**RE: DENDROBIUM MINE – PLAN FOR THE FUTURE: COAL FOR STEELMAKING (SSD 8194) –  
WOLLONGONG CITY COUNCIL RESPONSES**

ATTACHMENT 1  
RESPONSE TO WOLLONGONG CITY  
COUNCIL COMMENTS

## WOLLONGONG CITY COUNCIL – SUBMISSIONS REPORT RESPONSES

Dendrobium Mine Plan for the Future
 Visibility Analysis
 Proposed Ventilation Shaft Sites
 Construction Infrastructure Visibility

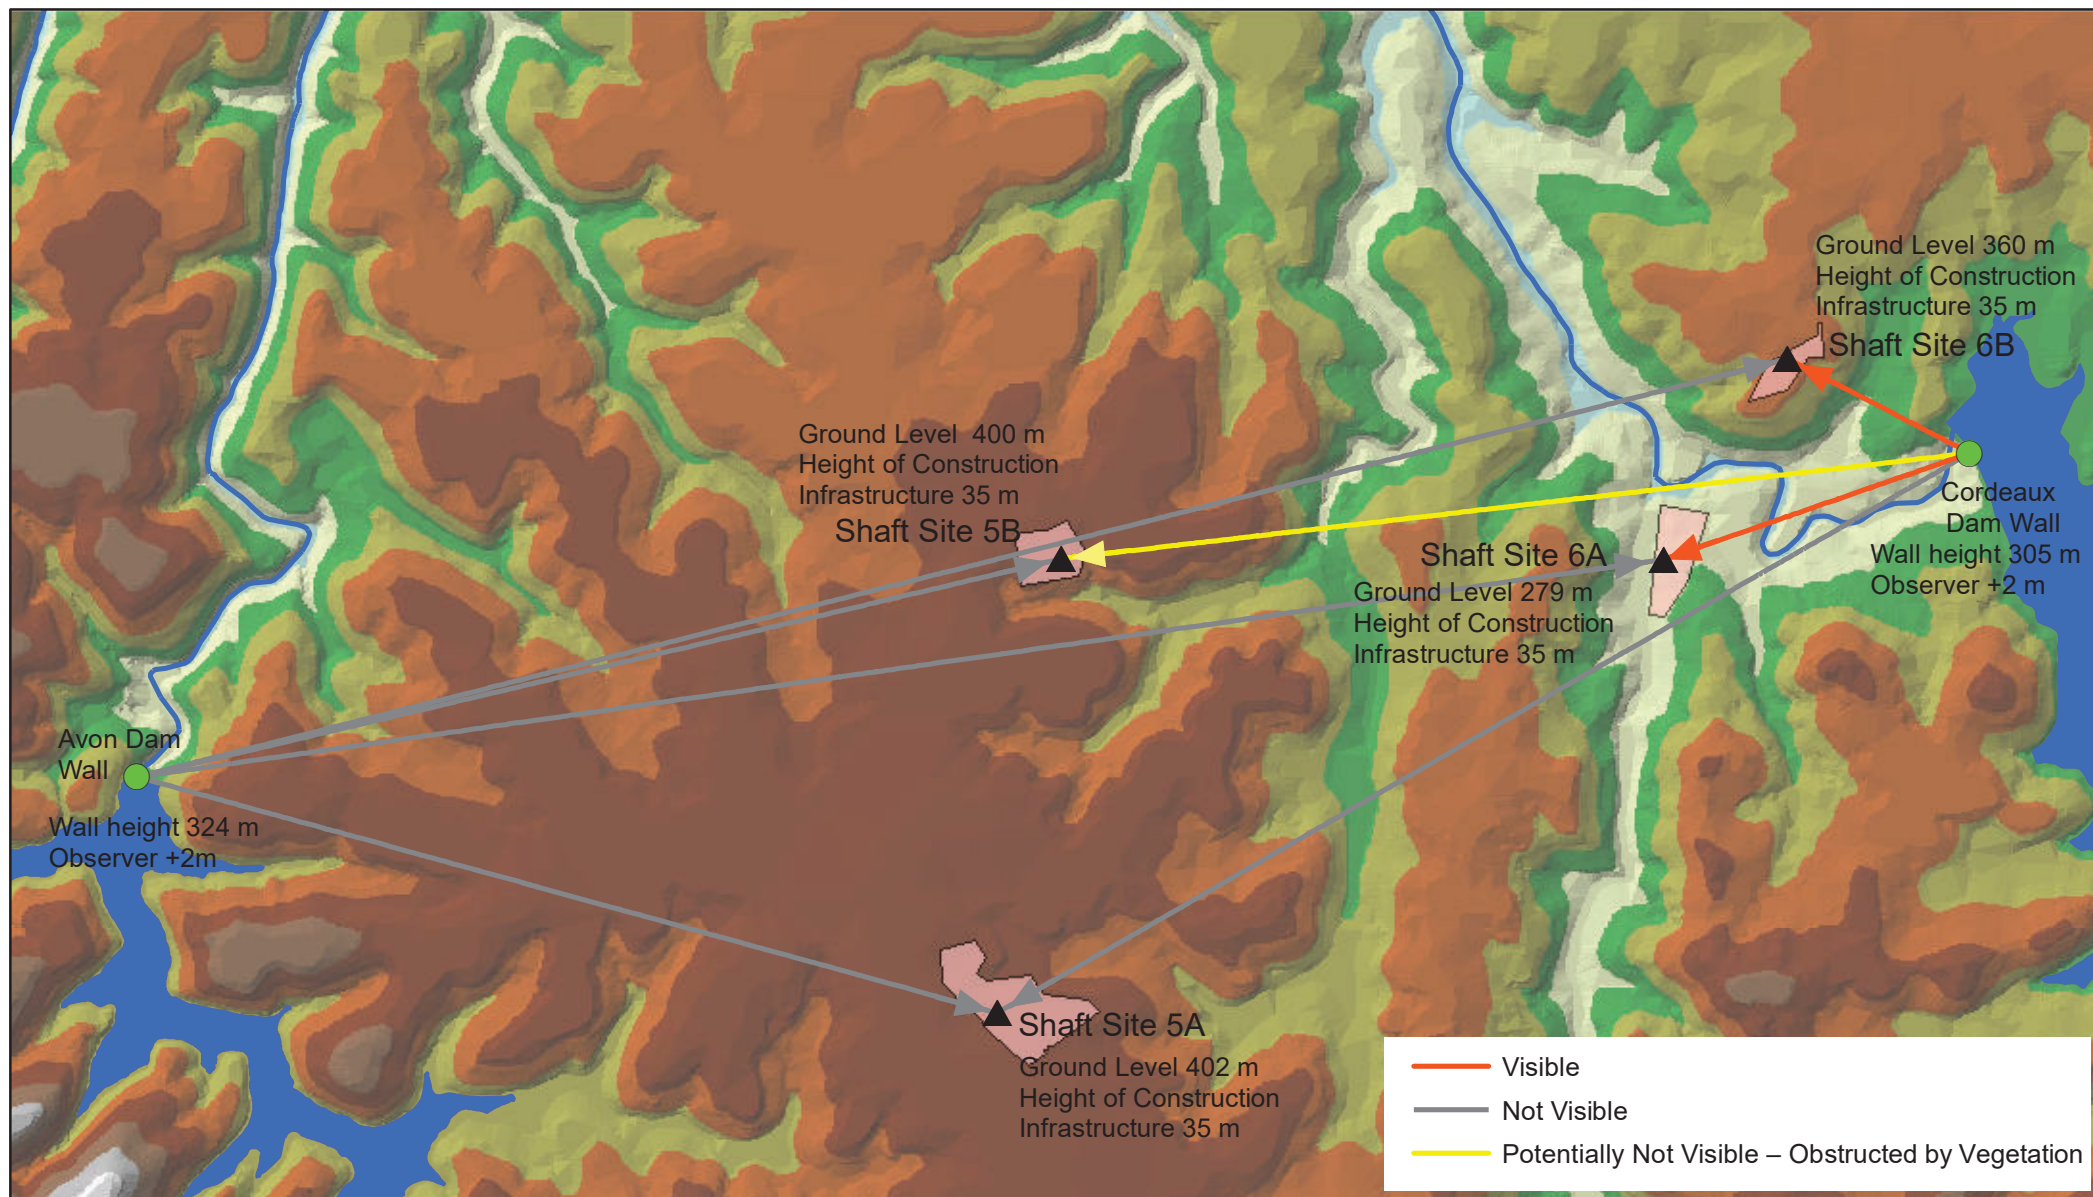
*The impacts of the proposed 15 metre high ventilation shafts on the Illawarra Escarpment Conservation Area are not addressed in the HHA report ... In Council's view, a comprehensive visual impact assessment should be prepared and included as part of the EIS.*

The Illawarra Escarpment Conservation Area is more than 10 km away from the proposed ventilation shaft sites for the Project.

The potential visual impacts of the proposed ventilation shaft infrastructure on identified items of historic heritage are described in the Historic Heritage Assessment (Appendix G of the Project EIS), in particular, from the Avon and Cordeaux dam walls, which are approximately 4.5 km and 1 km away from the closest proposed ventilation shaft sites, respectively.

The basis for the assessment of potential visual impacts by Niche (2019) is illustrated in Figures 7, 8 and 9 of Appendix G of the EIS (reproduced below), and shows that the dam walls were selected as the viewpoints for the assessment as they are the publicly accessible recreational areas with potential views of the infrastructure.

As such, it is anticipated that the Project ventilation shaft sites would have negligible visual impact on the Illawarra Escarpment Conservation Area.
